**Rezoning Transportation Analysis**  
**Petition Number: Insert Zoning Petition #2020-181**  
*General Location Identifier: 11122105*

**Revision Log:**

Date	Description
01-21-21	First Review (WB)

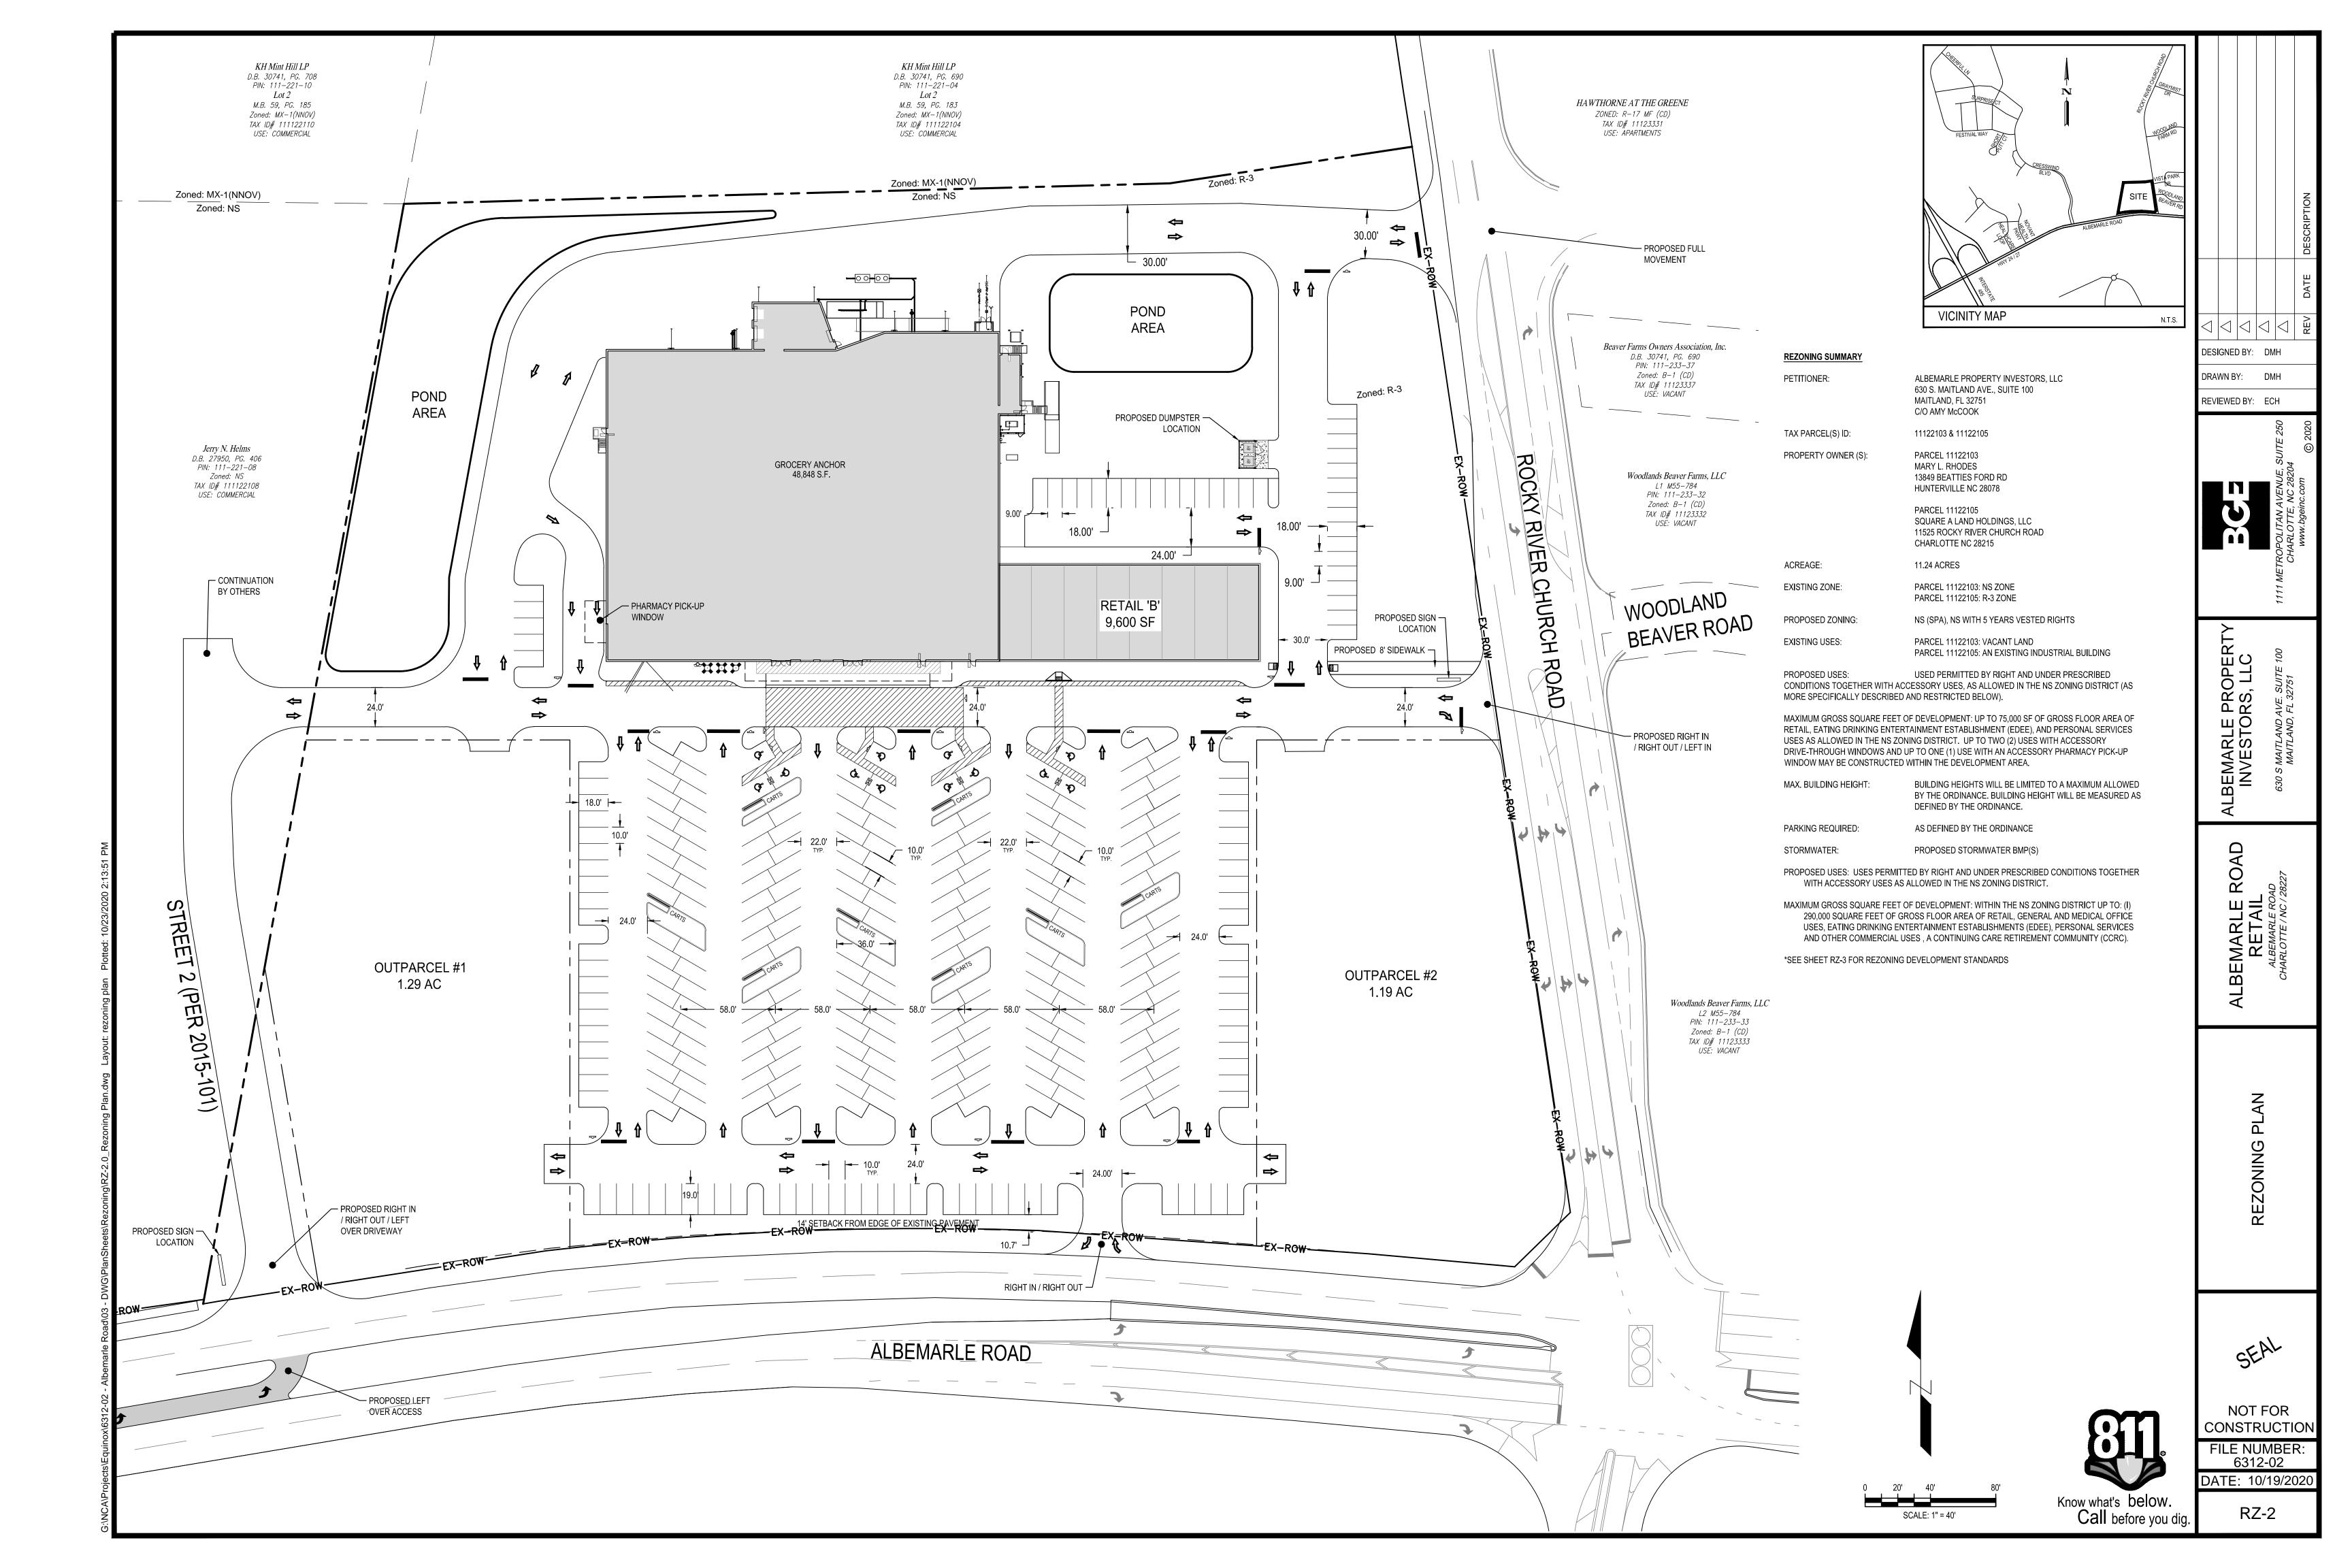
1. **Curblines:** The proposed zoning district has a setback measured from back of the existing or proposed future curblines.
  - a. **Albemarle Road:** The site plan reflects the future location of curb and gutter.

Label and dimension the curb and gutter from the centerline for each road on the site plan.

2. Revise site plan and conditional note(s) to commit to constructing public streets 2 and 3 per Rezoning Petition 2020-101. Each proposed public street shall include an 8-foot planting strip and an 8-foot sidewalk on proposed public streets per CLDSM standards and Chapter 19 of the City ordinance. The site plan shall label and dimension both items from the back of curb and gutter and road centerline.

3. Site plan and conditional note(s) revisions are needed to commit to constructing a 12' multi-use path with an 8' planting strip along the site's frontage in accordance with the Charlotte BIKES and Charlotte WALKS Policies. The petitioner should coordinate with the developer of Approved Rezoning Petition 2020-007 to ensure that intersection improvements provide continuity between the multi-use path and planting strip on both sides of Rocky River Church Road. The site plan shall label and dimension both items from the back of curb and gutter and road centerline.

2. Revise site plan and conditional note(s) to commit to constructing a concrete median with a left-over on Rocky Rover Road to maintain left turns into Woodland Beaver Rd and prevent left turns into the site's southmost access into the site.

5. Site plan and conditional note(s) revisions are needed to commit to providing intersection improvements to accommodate pedestrian and bicycle crossings at the Albemarle Road and Rocky River Church Road Intersection. These improvements shall include accessible ramps, channelization islands and all associated infrastructure modifications needed to provide a safe route for both bicyclists and pedestrians and align with those improvements found and approved as part of RZP 2020-007.
